Application No: K/2/22/HH
Site Address: 43 Golden Avenue East Preston BN16 1QX
Description of works: 2 storey front and rear extensions and alterations.

Planning Application No. K/2/22HH - 43 Golden Avenue

Proposed Second Floor Plan

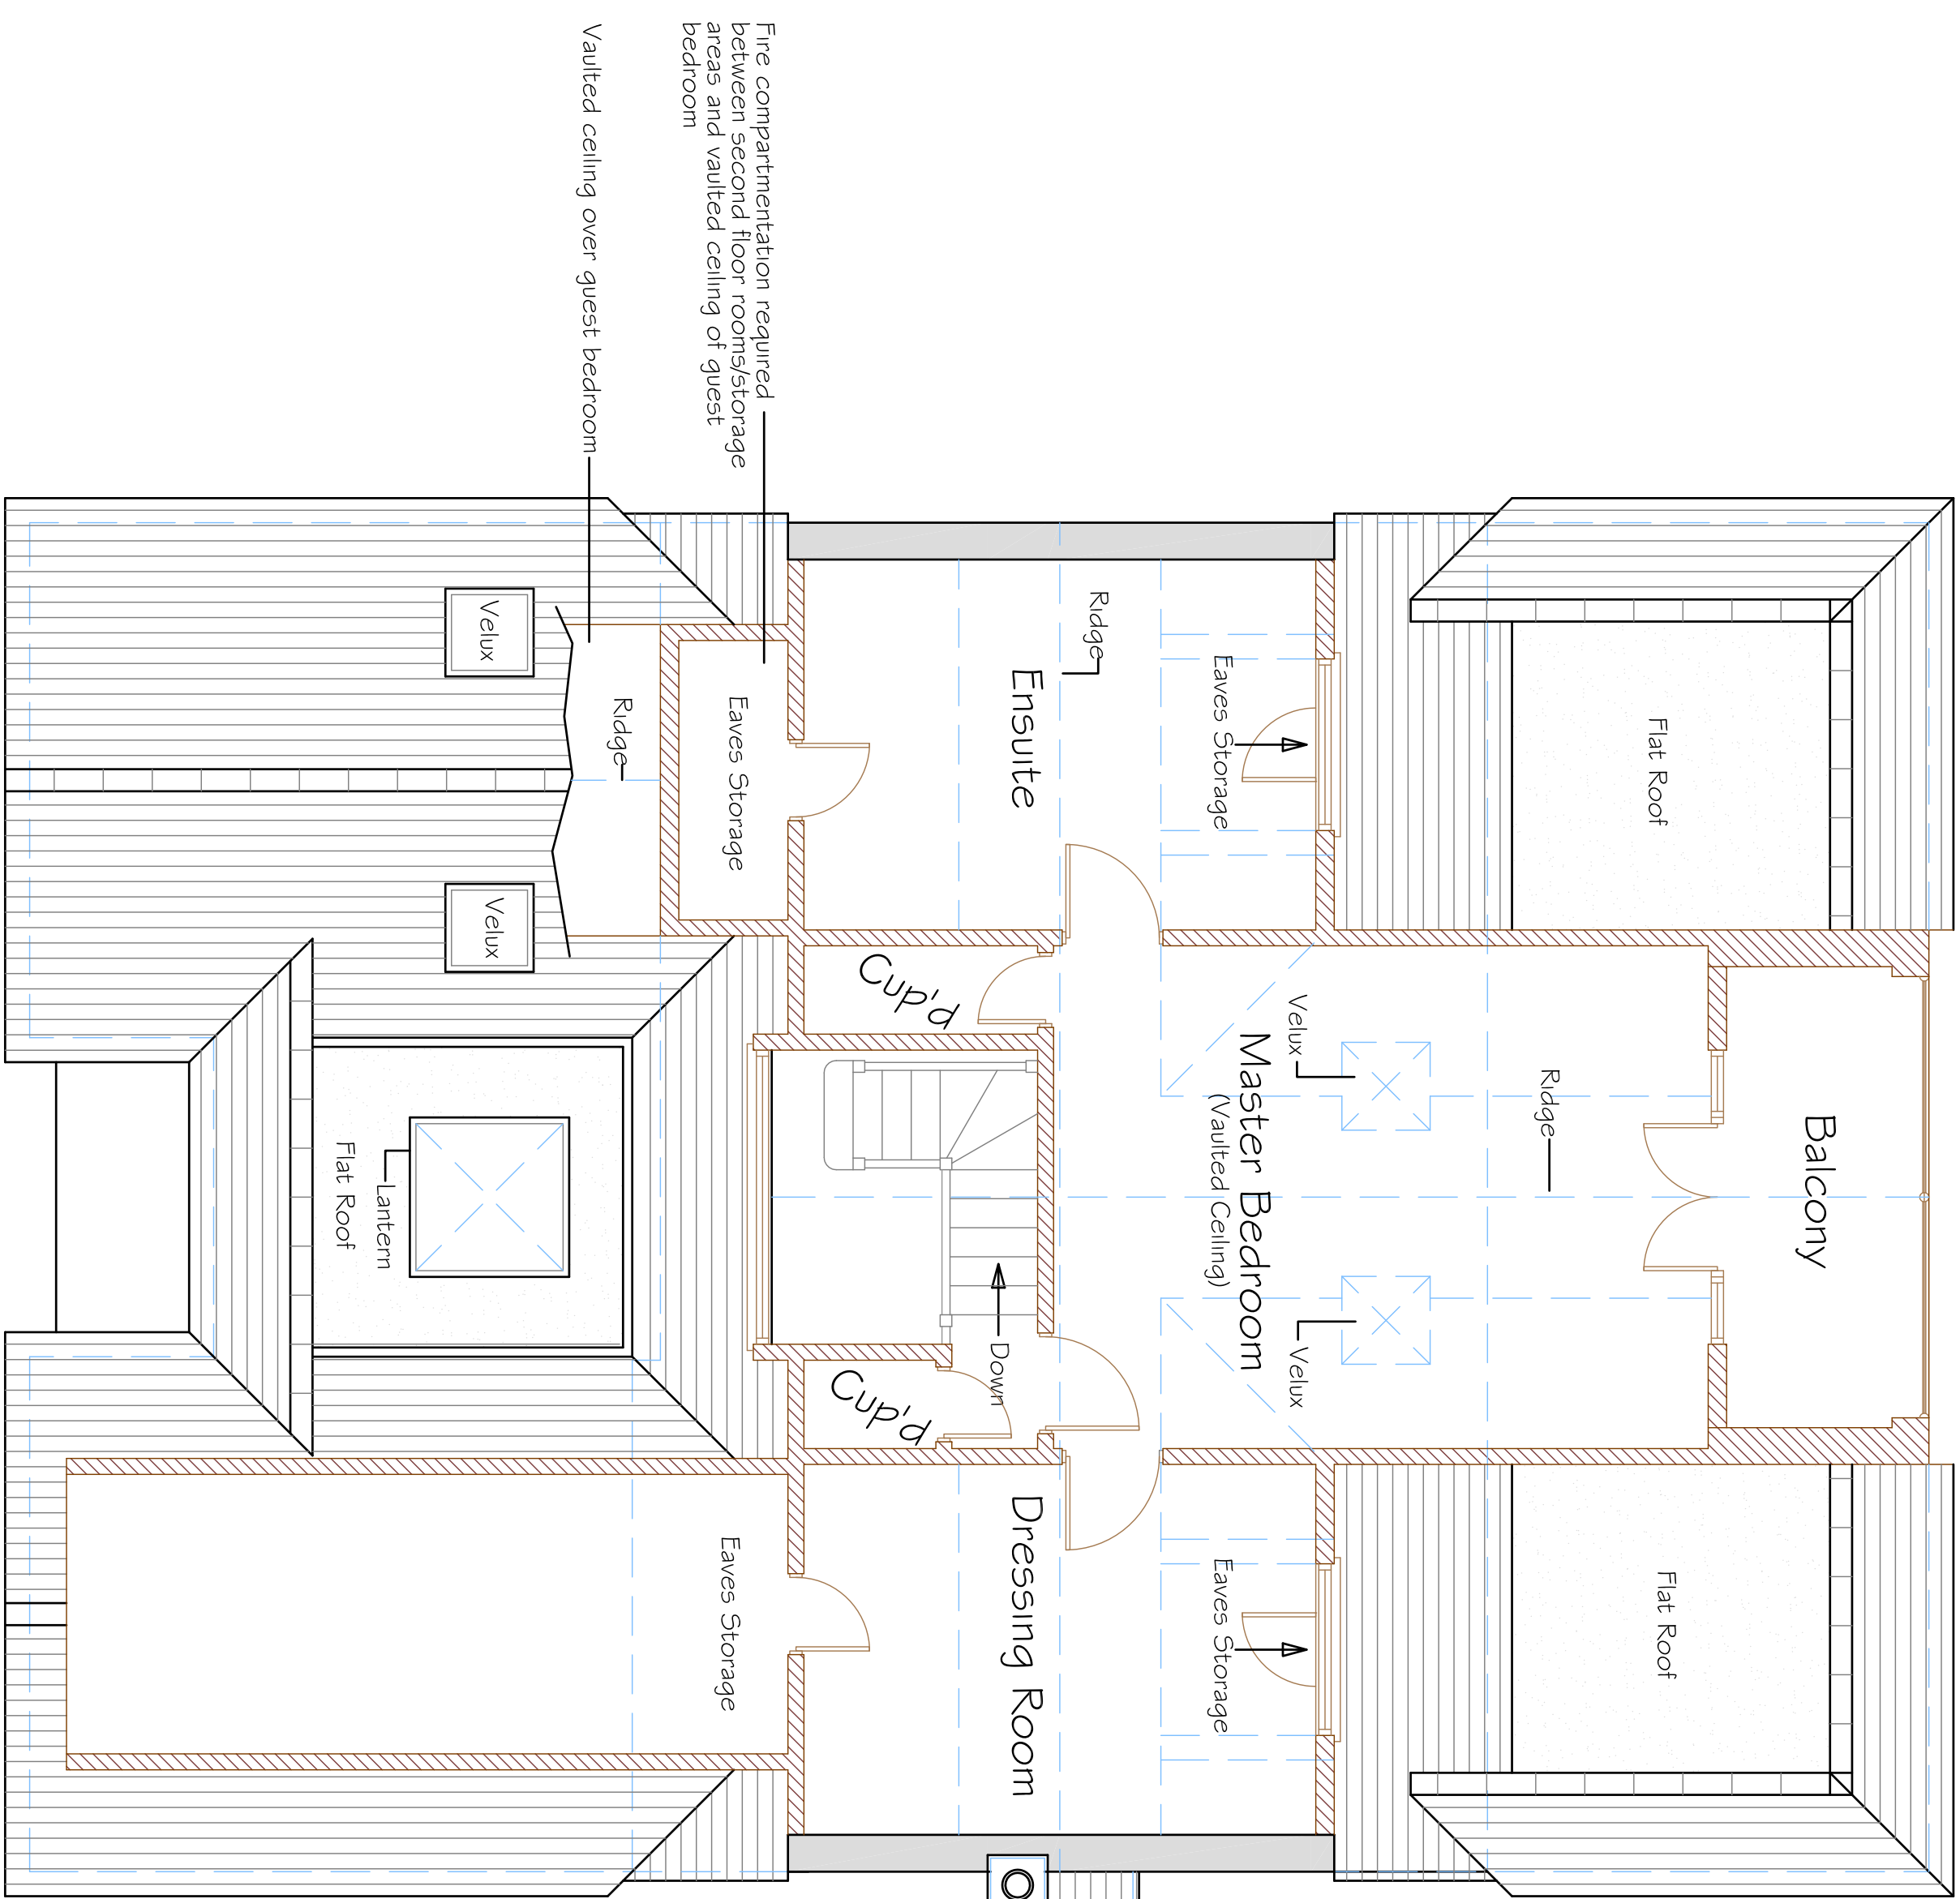
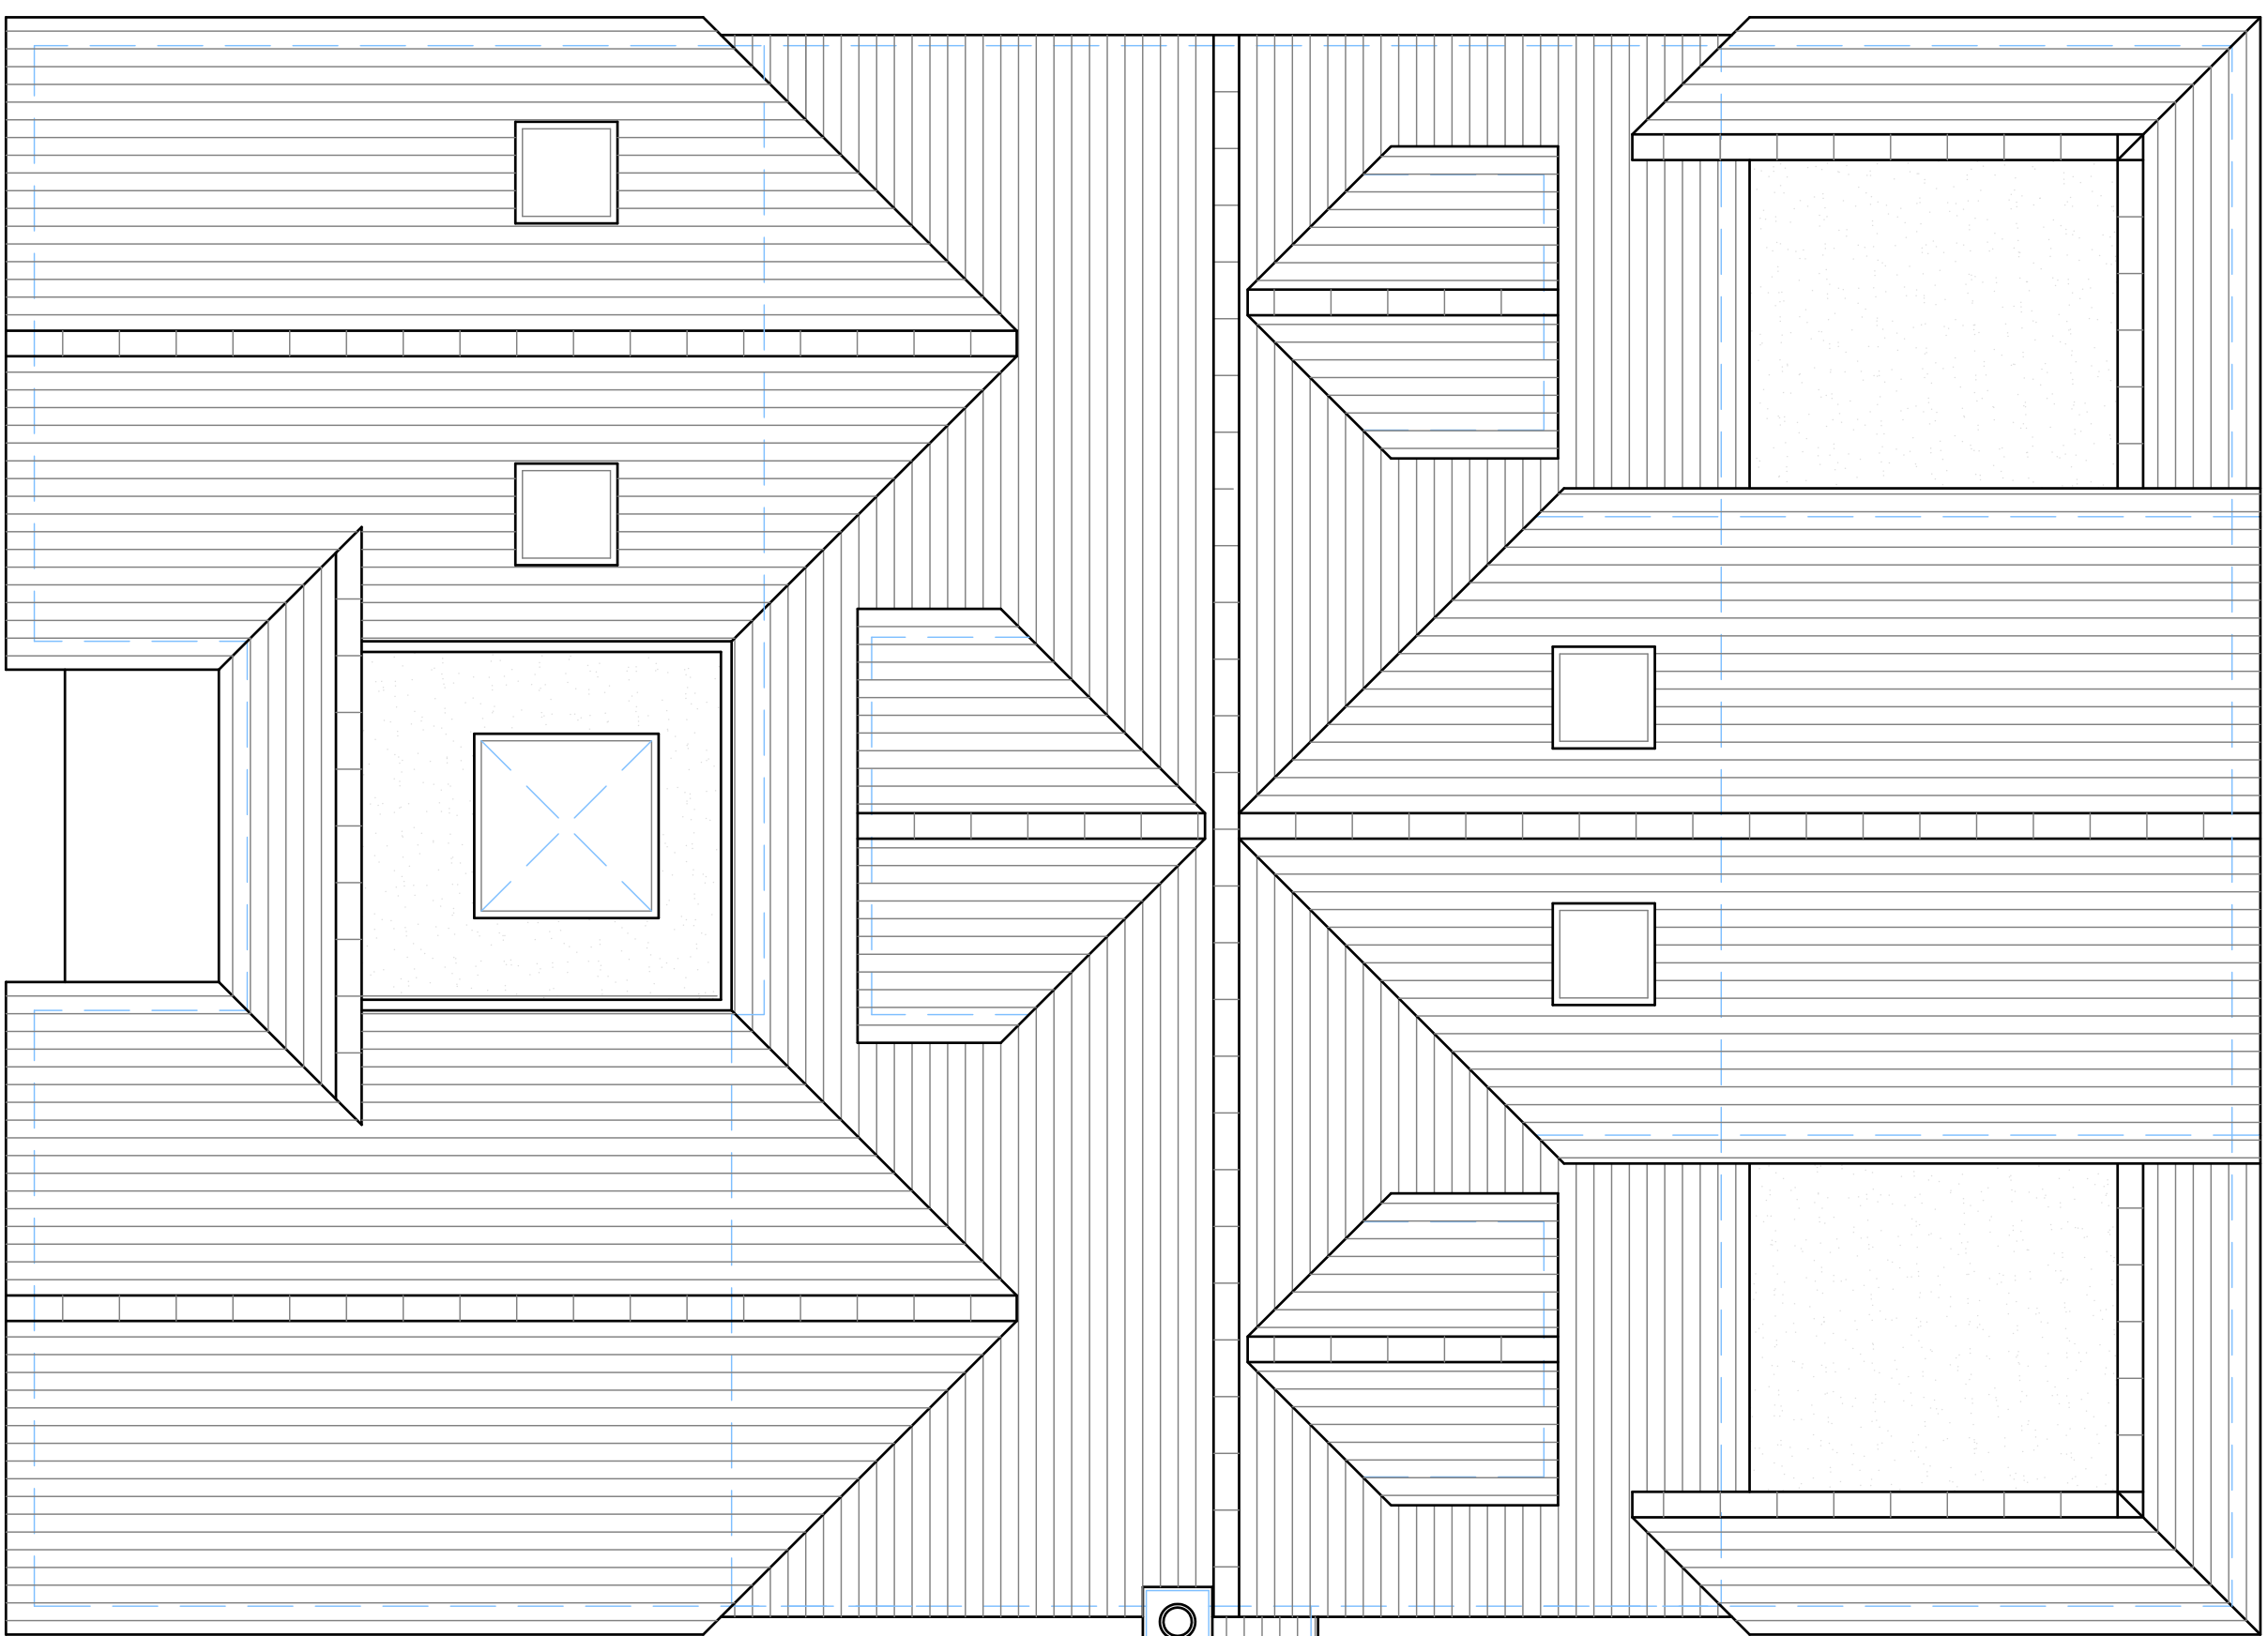
Further concerns that we have observed with the rear extension and the central roof accommodation is the depth and especially the height to the top of the central dormer styled room and roof. The consequence of
